PUBLIC SUBMISSIONS

Proposed Shadows March 21, 3 PM

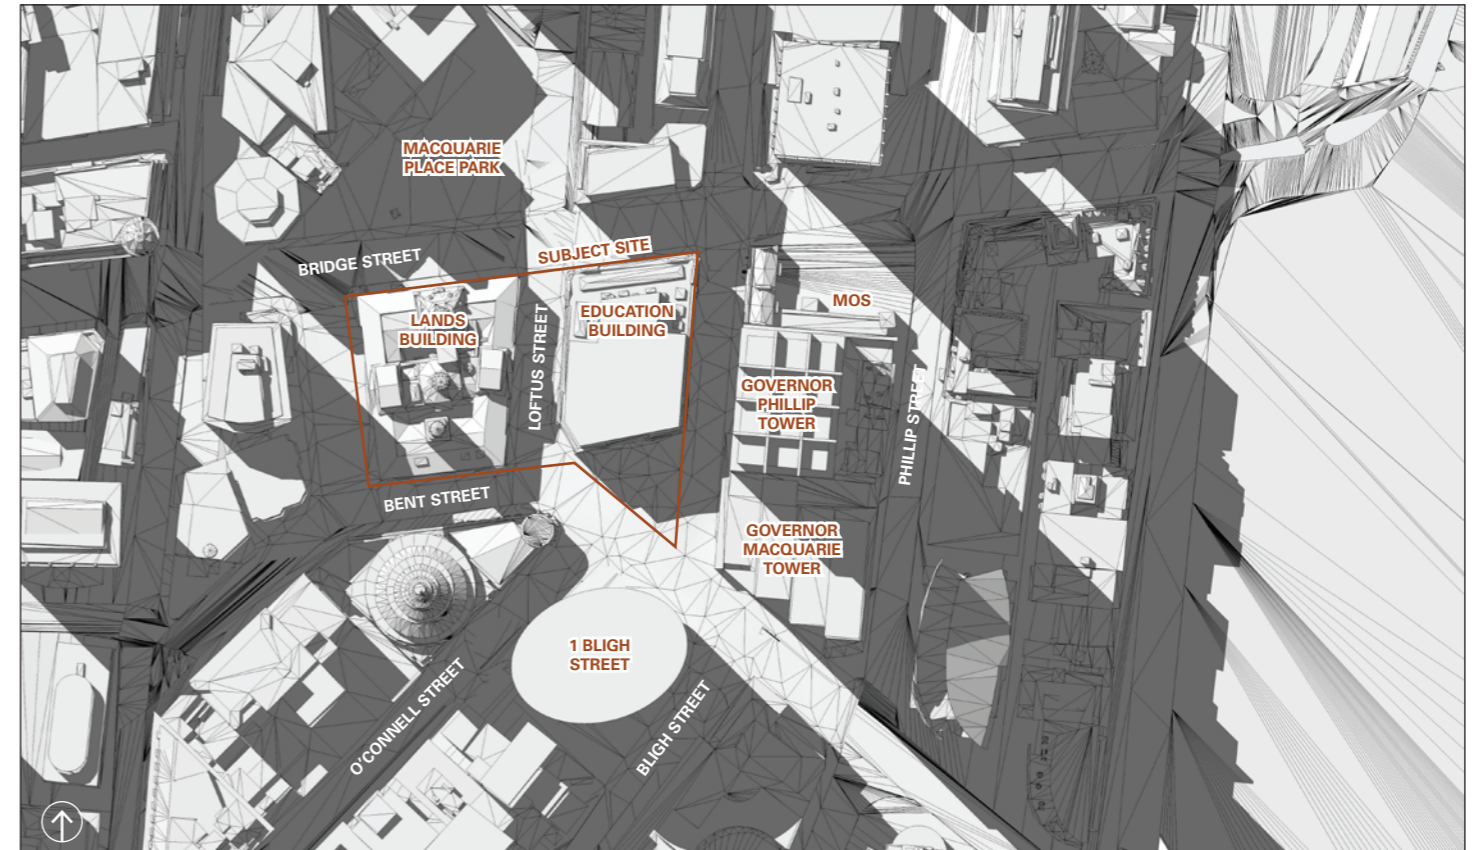
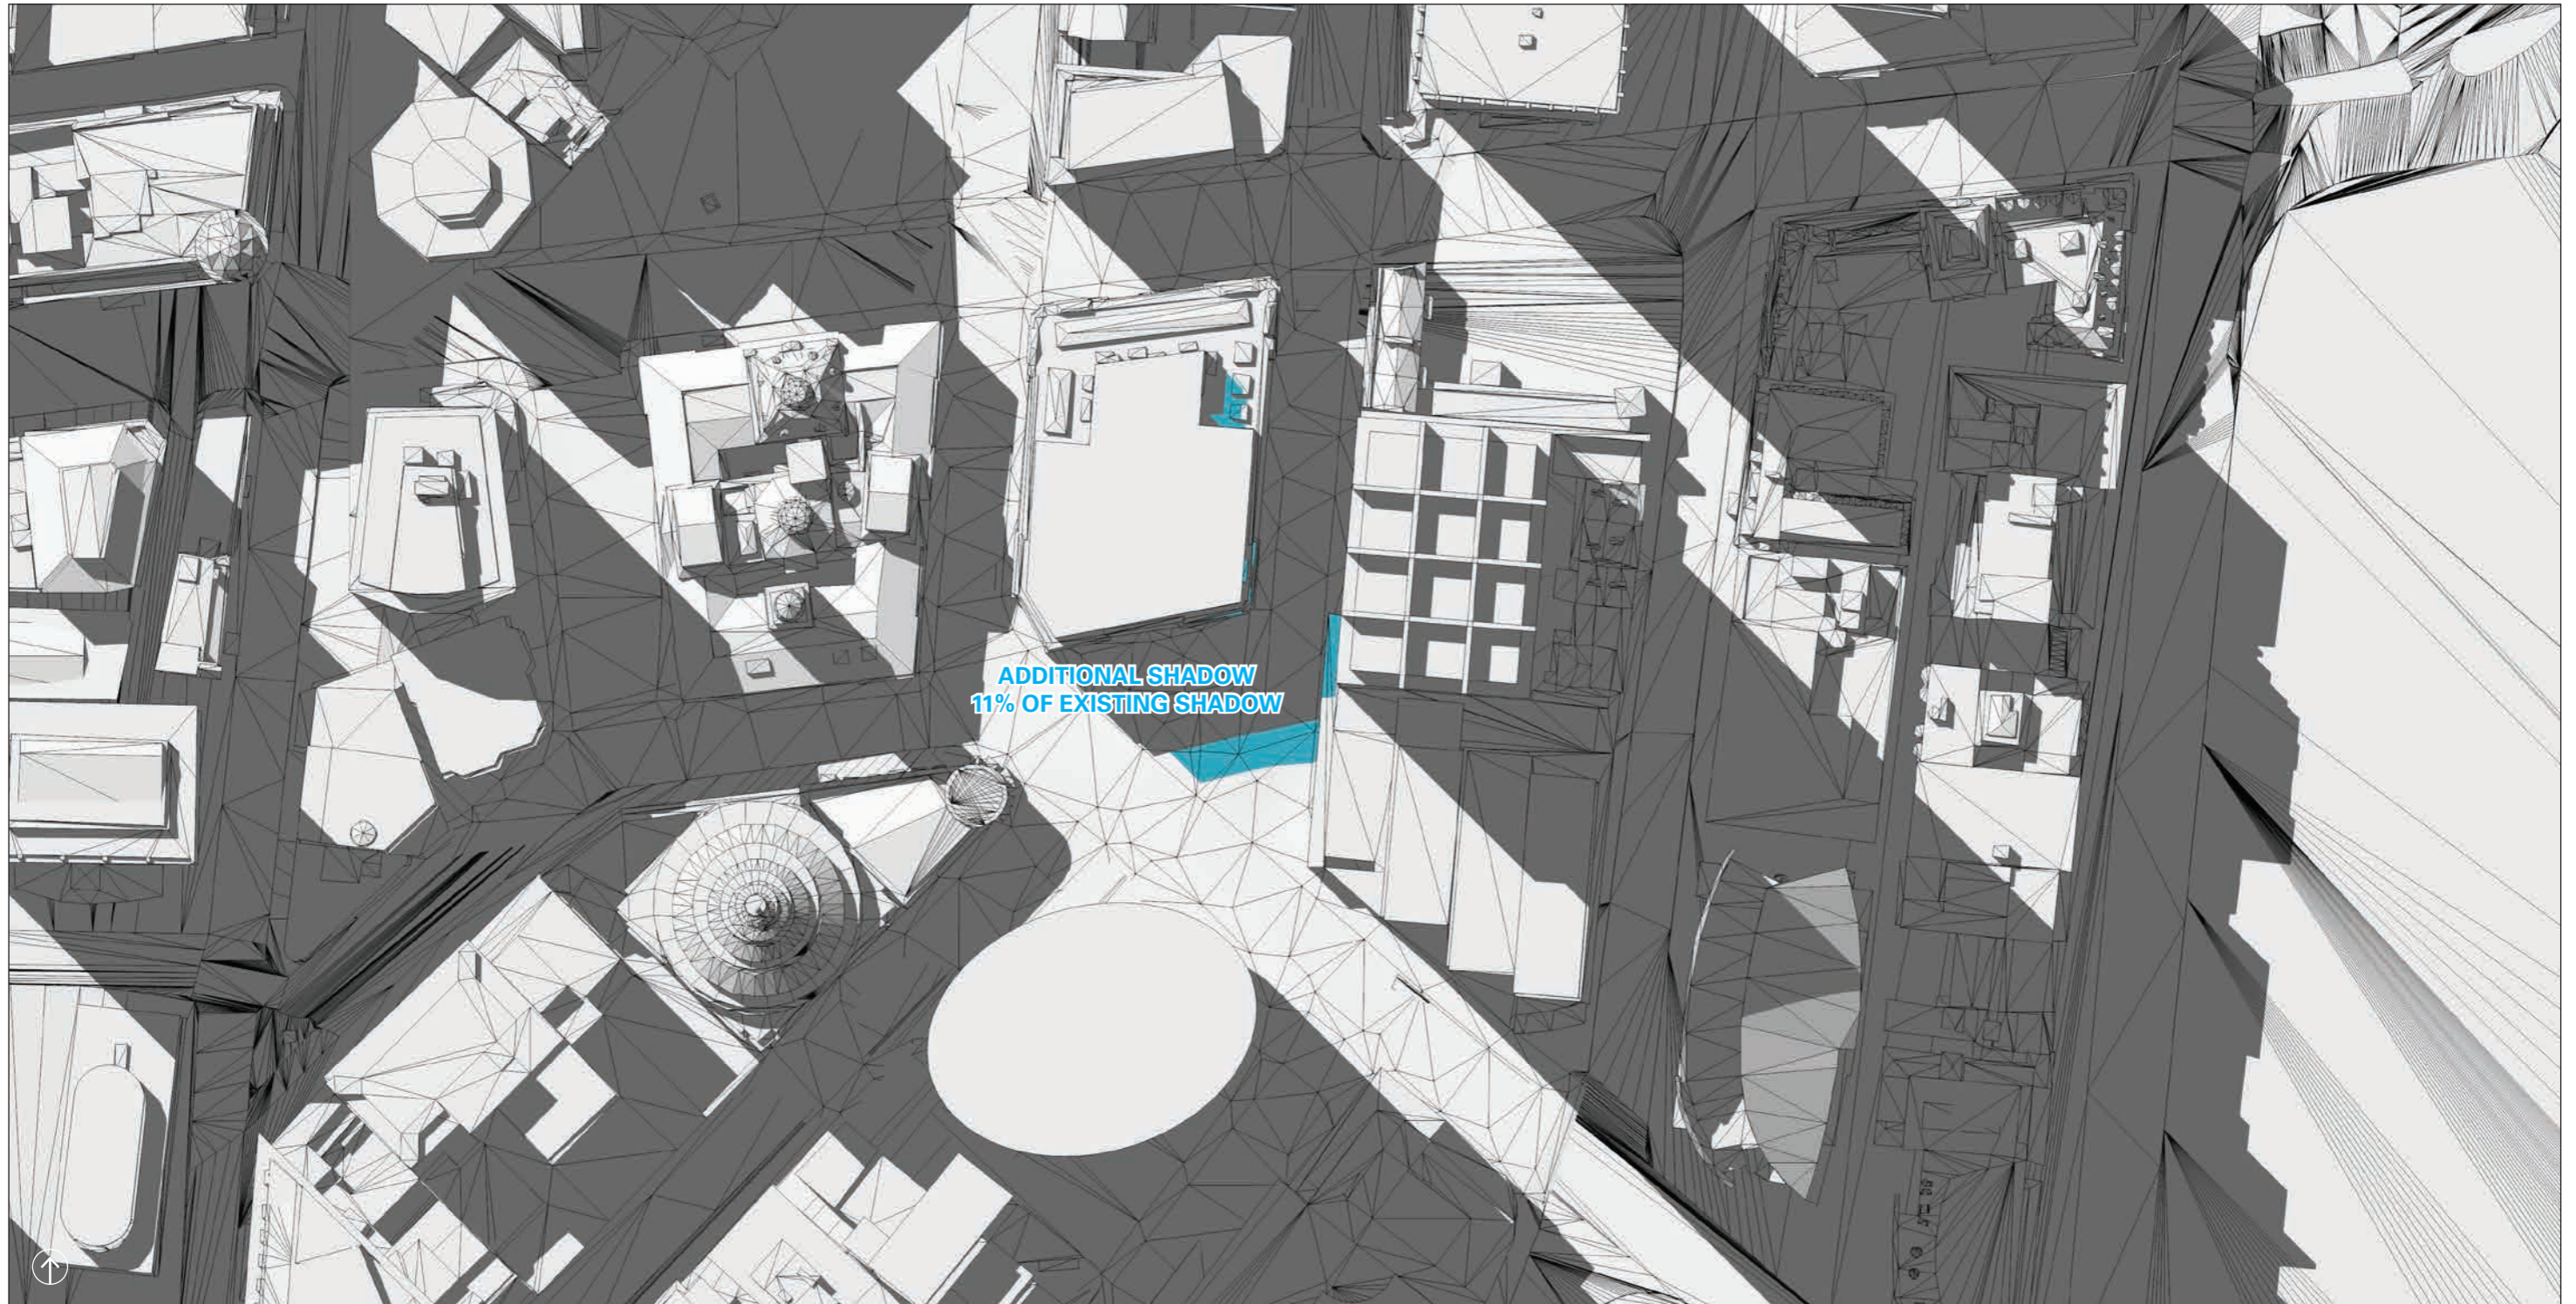
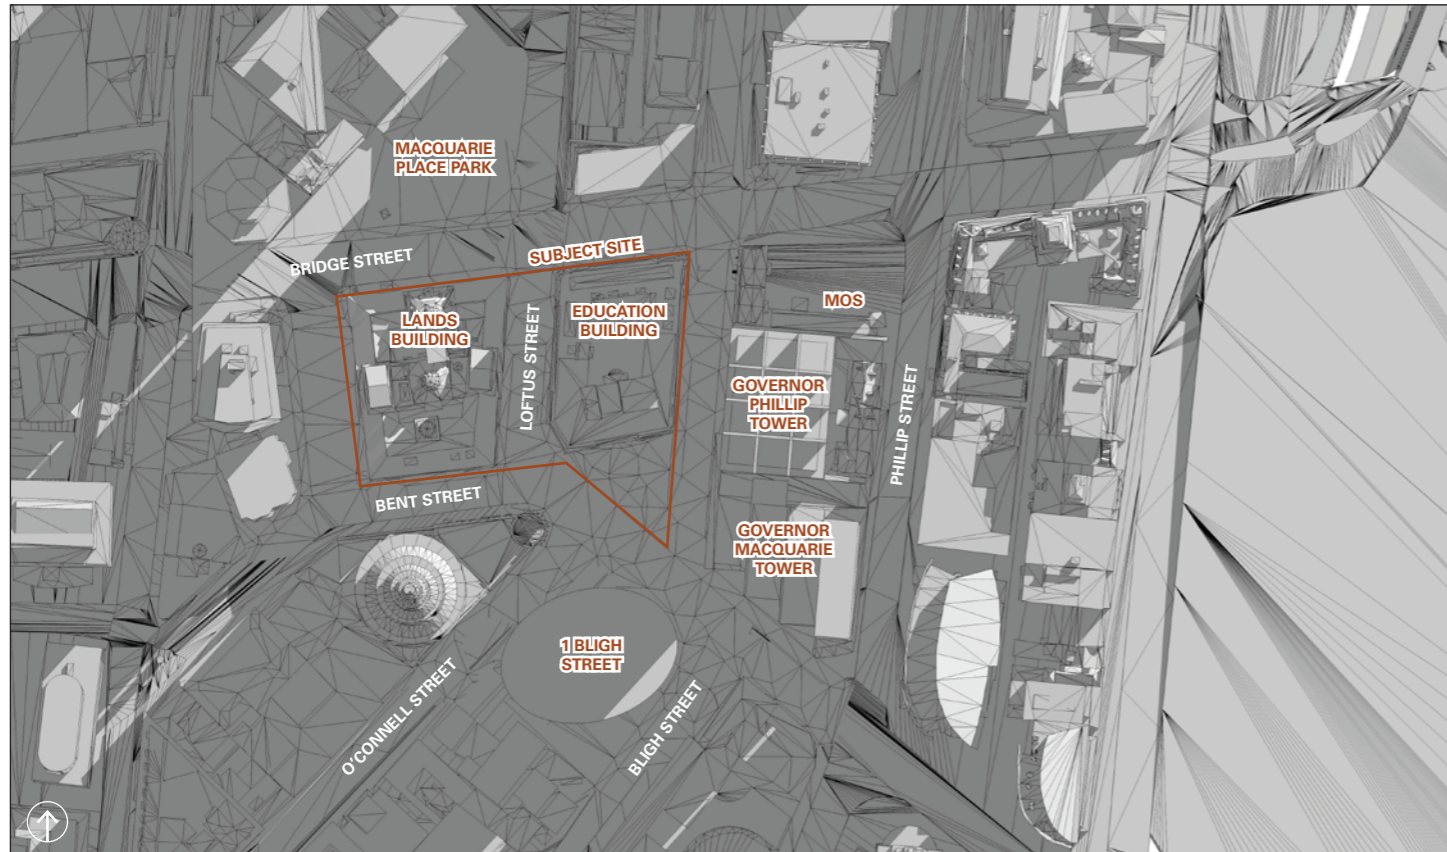
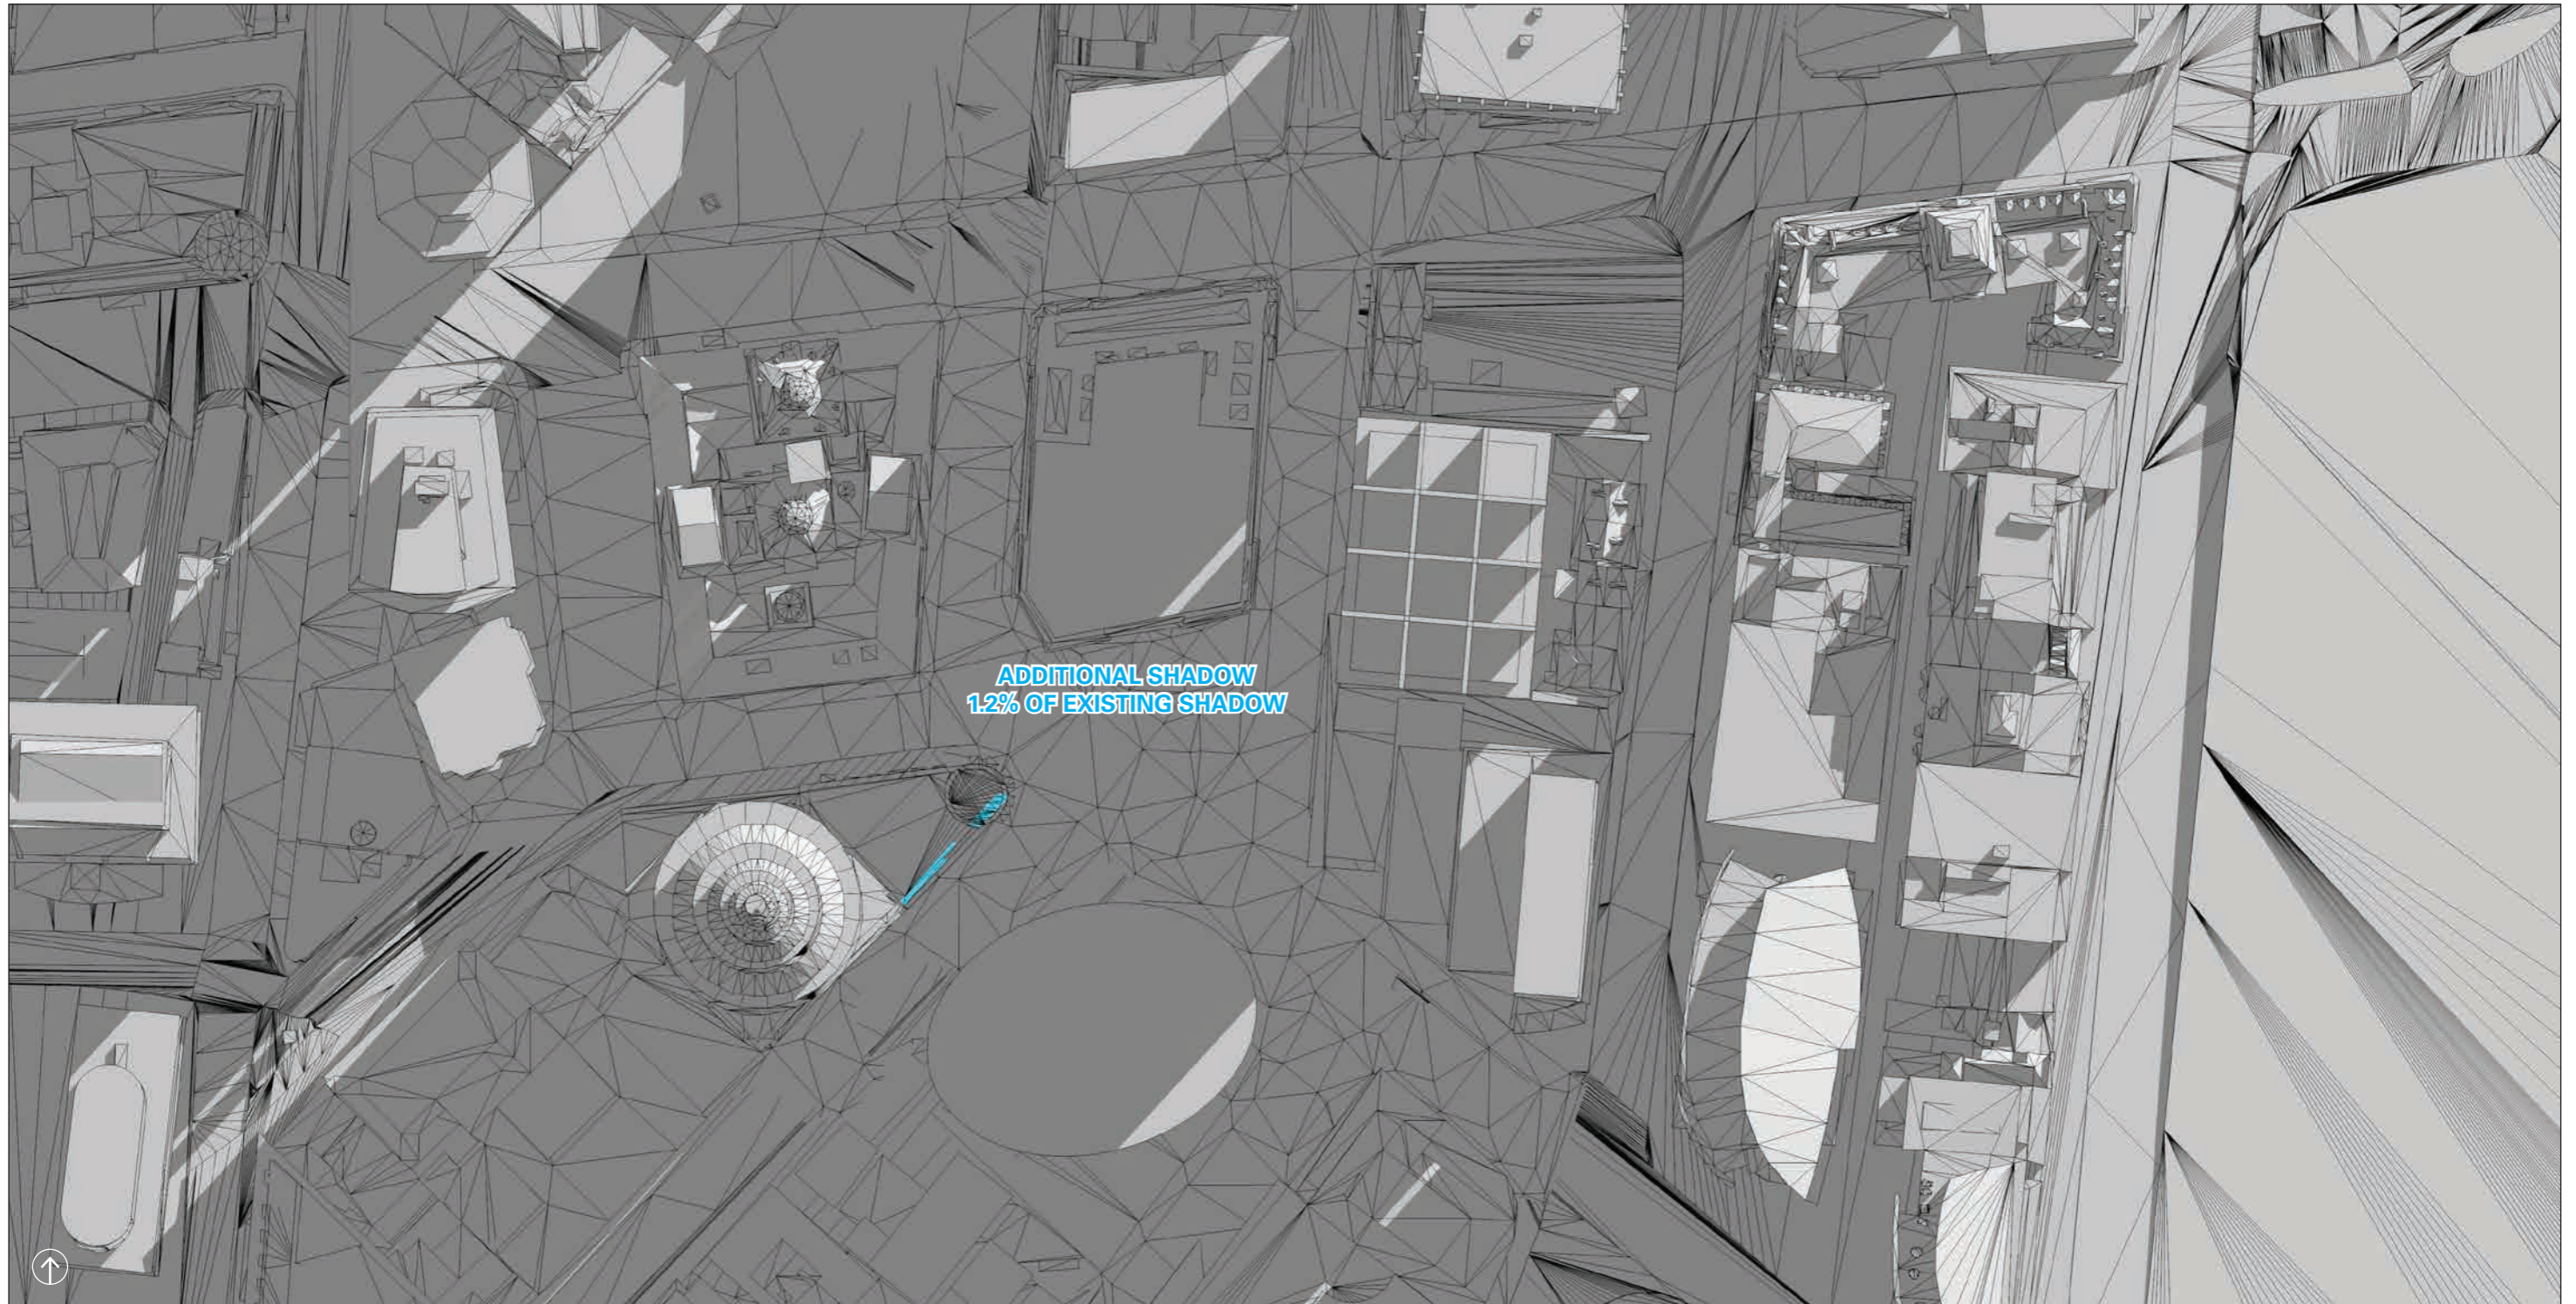
| <p>HEIGHT/OVERSHADOWING</p> <p>Increase in overshadowing</p> <p>Height increase is unacceptable when viewed from adjoining streets (should be setback)</p> <p>Rooftop additions should be setback</p> <p>The additional floors which create unacceptable shadow impacts on Farrer Place.</p> <p>The additional floors will create overshadowing on the Lands Building, which has not been addressed.</p> | <p>6</p> | <p>Clive Gunton</p> <p>Philip Drew</p> <p>WITHHELD</p> <p>WITHHELD</p> <p>John Freeman</p> <p>Peter Webber</p> | <p>See Section 2.1 of the Response to Submissions (RTS).</p> |
